From: Laura Gibbons
Sent: 10 June 2019 14:02
To: Planning.Responses
Cc: Anita Gardner
Subject: RE: Planning Consultation on FG/62/19/DOC

Engineers comments regarding condition 3- surface water drainage

APPLICATION **FG/62/19/DOC**

Description of Works: Approval of details reserved by condition imposed under FG/203/18/PL relating to conditions 3-surface water drainage, 4-details of materials & finishes, 5-Construction Management Plan & 6-covered & secure cycle parking spaces.

LABC Drg No 6454

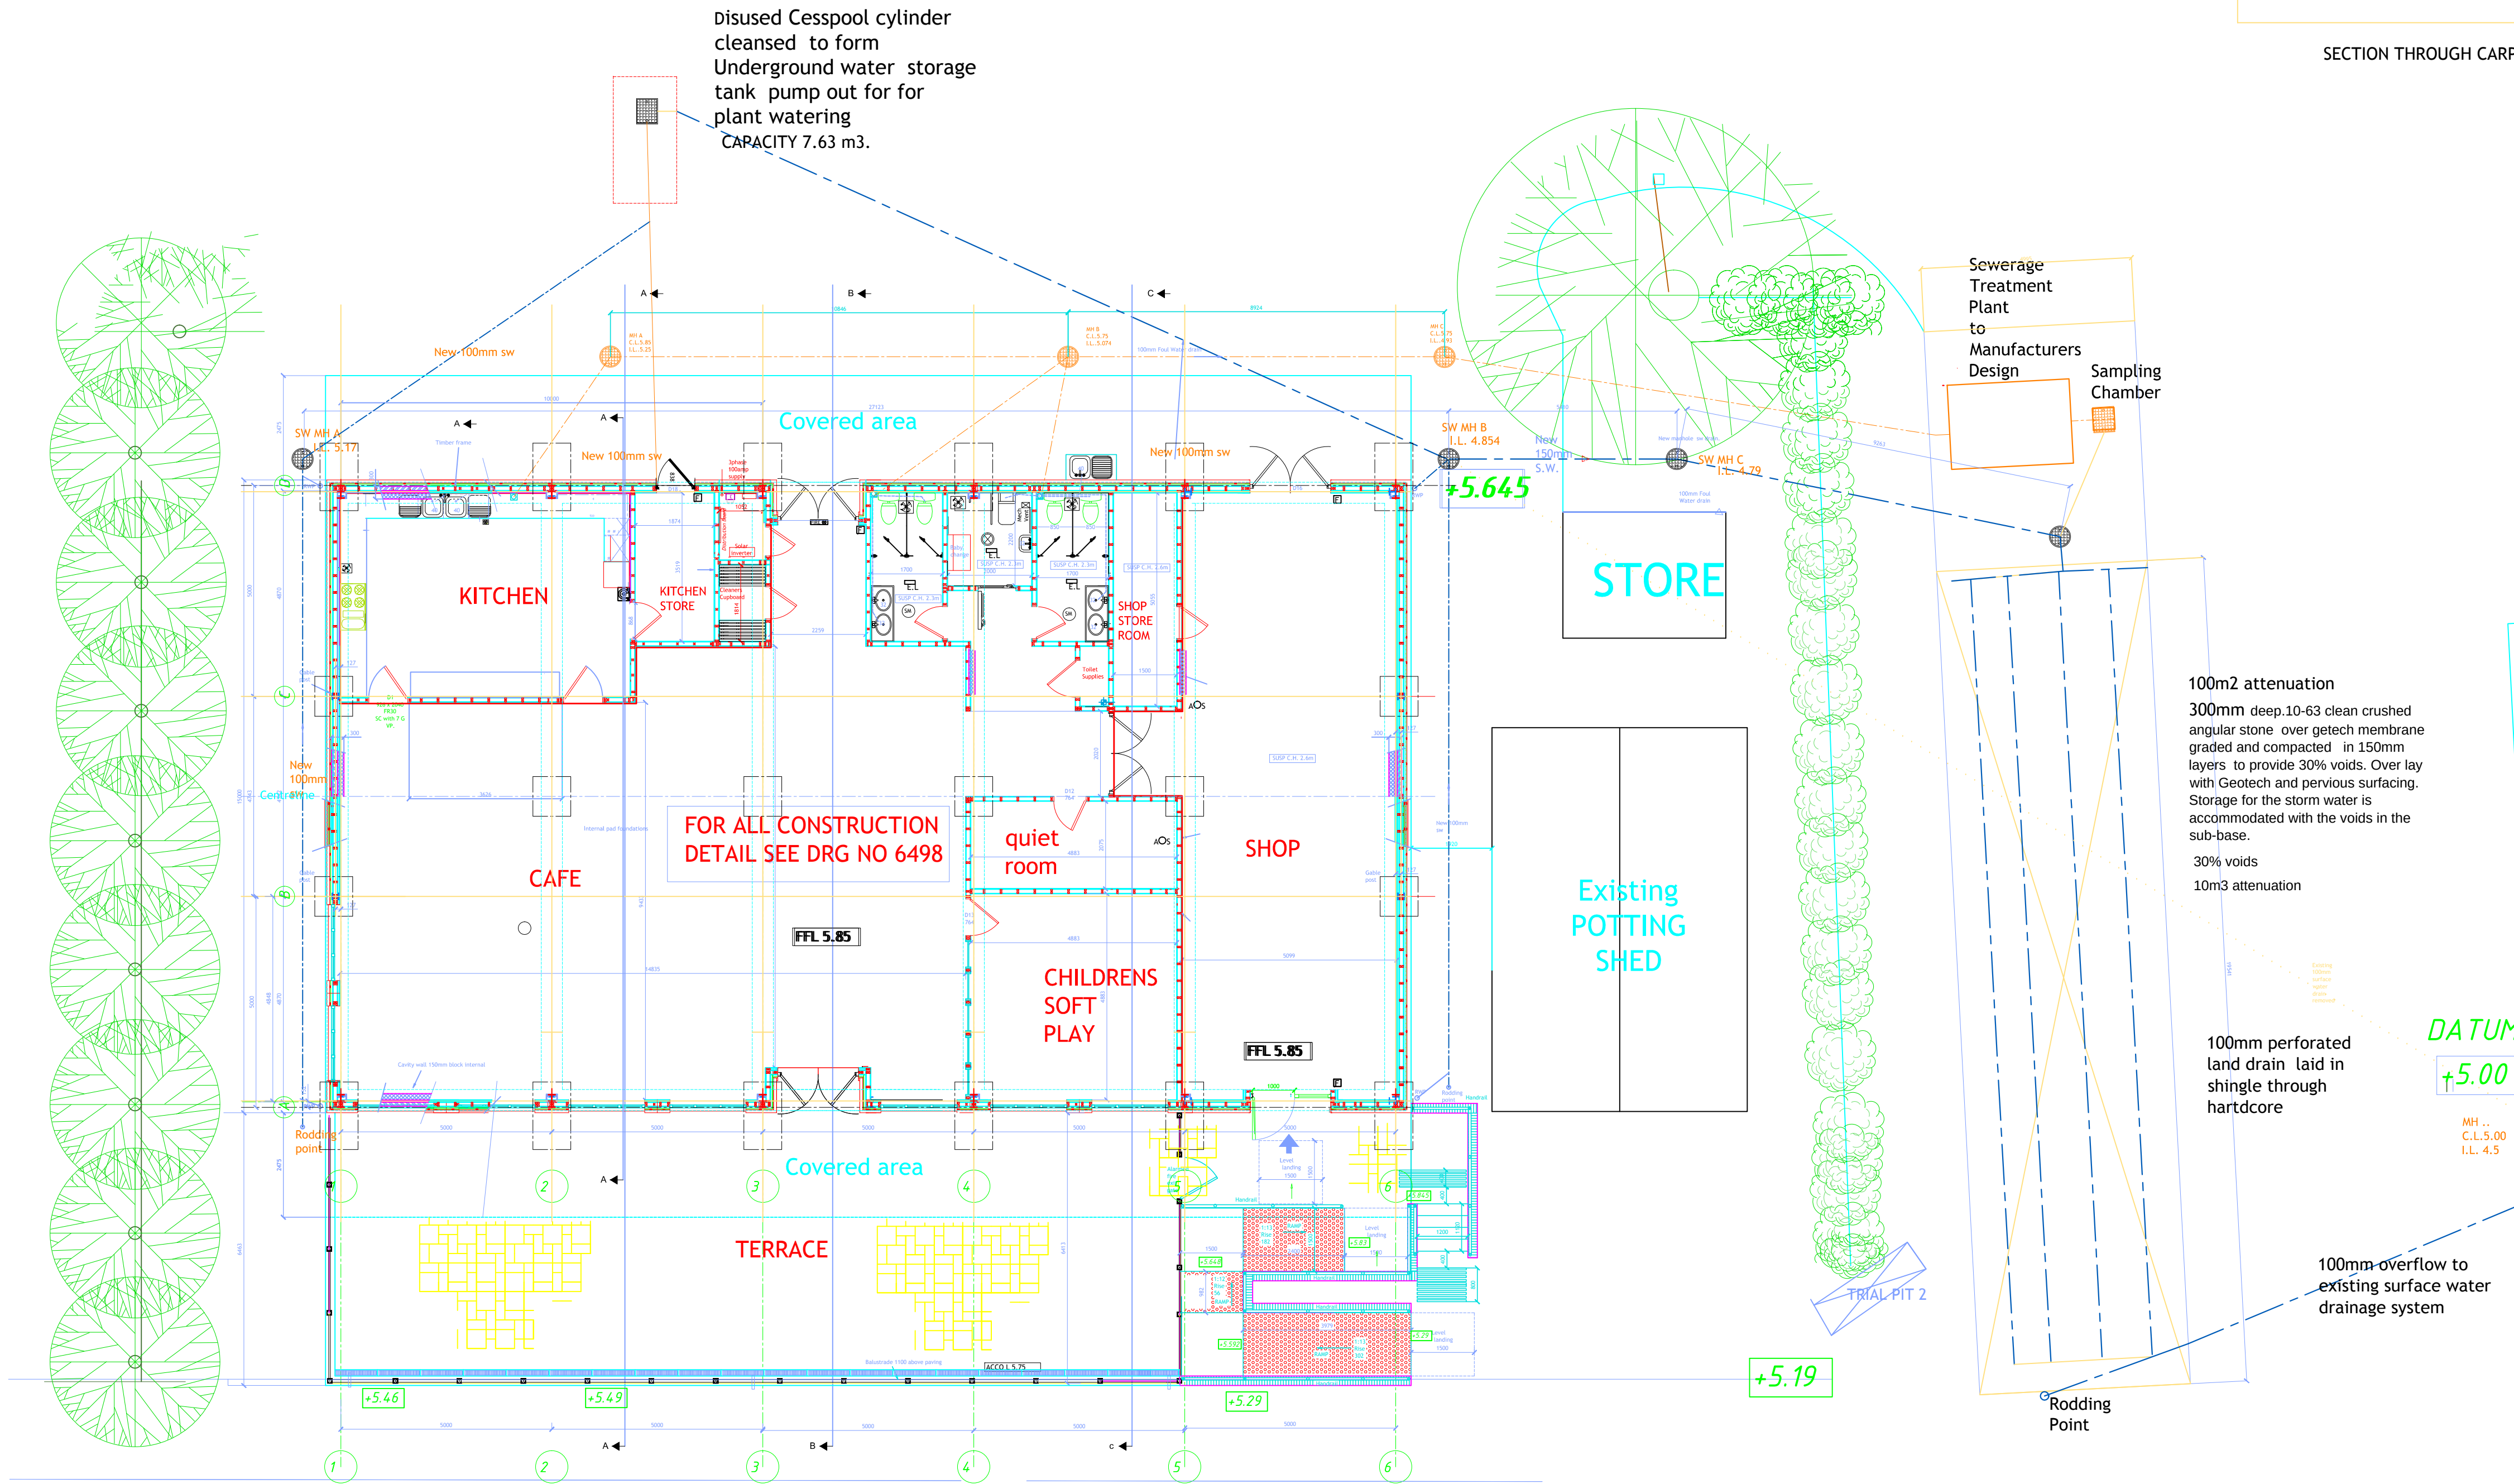
3. It is unclear where the assumption that only 50% of the roof runoff requires storage within the sub-base has been derived from.
4. The existing soakaway should not be included within calculations as it has been found that this may not be utilisable at times of high ground water. The proposals for a high level overflow connecting to this can be taken forwards if it is found to be required.

5. Half drain time calculations should be submitted.
6. Cover levels need to be provided at manholes.
7. Invert and cover levels need to be provided on plan of the overflow pipe and the manhole upstream of the permeable surface area.

8. Finish and formation levels of the permeable surface need to be provided. Please also specify if a flat sub base is to be provided or not.
9. Please can results from the infiltration tests that are referred to be supplied as part of this application.
